Recommendation Report for Planning Permission for Works or Extension to a Dwelling

REF NO: FP/190/25/HH

LOCATION: 6 Westmorland Drive
Felpham
PO22 8LX

PROPOSAL: Single storey front porch extension.

PROPOSED ELEVATIONS

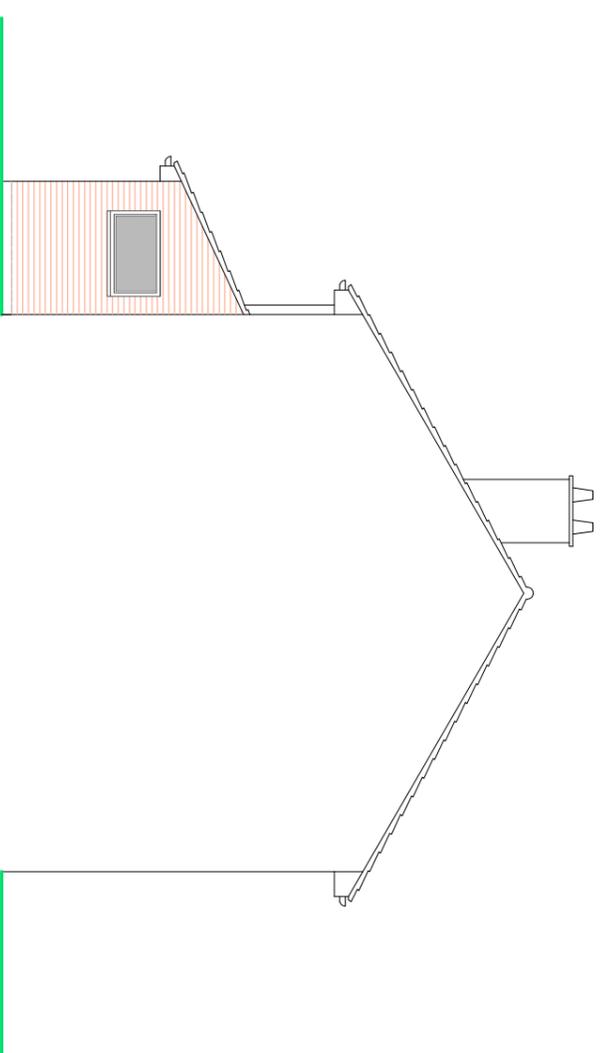
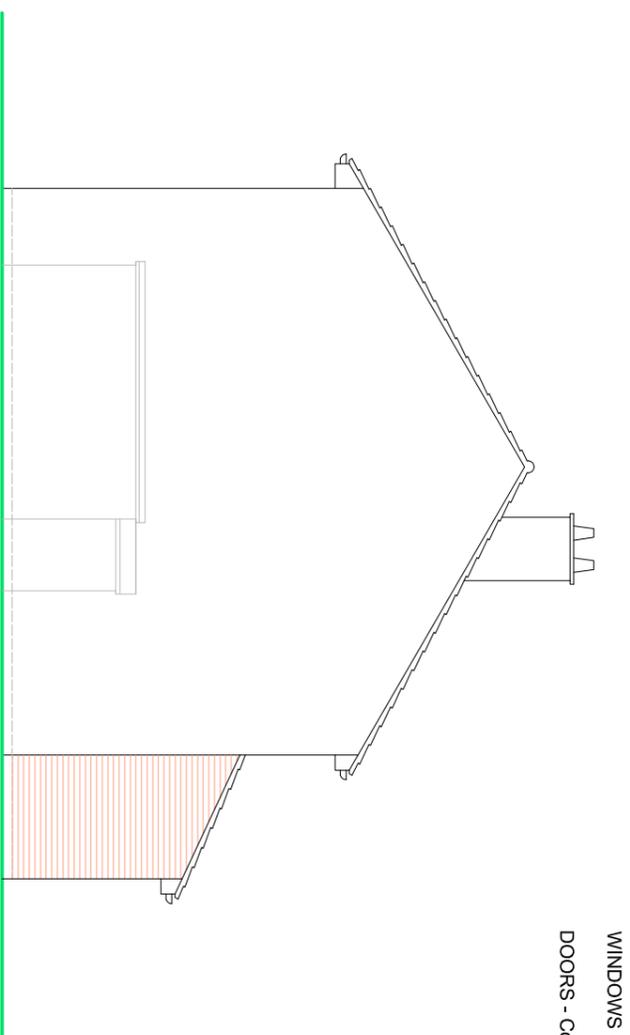
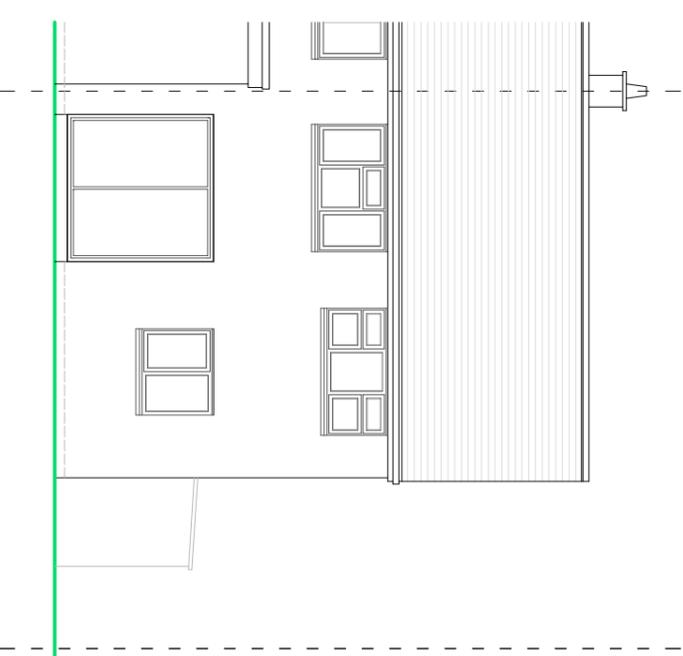
The Arun Design Guide (ADG) outlines that front extensions should generally be no deeper than 1.5m and should not be the full width of the building. The porch extension would have a depth of 1.9m and a width of 2.5m and would be set back approximately 4.2m from the highway. Whilst it is noted that the depth of the porch would exceed the guidance set out within the ADG, the porch would appear well integrated and subservient to the host dwelling due to its single storey nature, pitched roof form and use of materials to match the existing property. Furthermore, it is noted that a porch of a similar style, albeit a smaller footprint could be achievable under permitted development. As such, the proposed porch would not result in harm to the character or appearance of the host dwelling, street scene, or wider area.

The proposed porch would feature a side window on the south elevation serving a W/C. It is reasonable to condition this window to be obscurely glazed and non-openable below 1.7m above finished floor level to maintain the privacy of the neighbouring properties. As such, the proposed porch would not result in any increased overlooking.

- 3 The window on the south elevation of the porch extension shall at all times be glazed with obscured glass and non-openable below 1.7m above finished floor level. This arrangement shall be permanently retained thereafter.

### SITE PLAN - 1/500

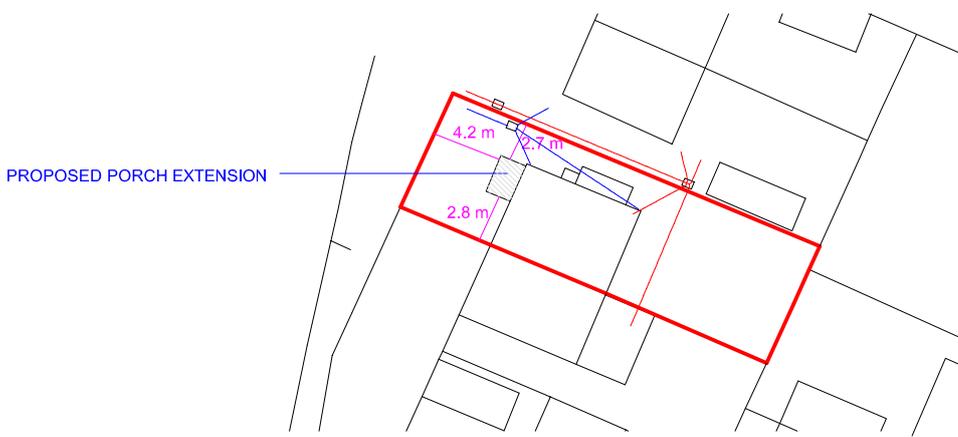
The front porch would be set in from the side boundaries of the application site by approximately 2.6m to the north boundary and 2.8m to the south boundary. Given the spacing between the front porch and neighbouring properties and the size and scale of the porch, the porch would not result in any overbearing or overshadowing effects to neighbouring properties.
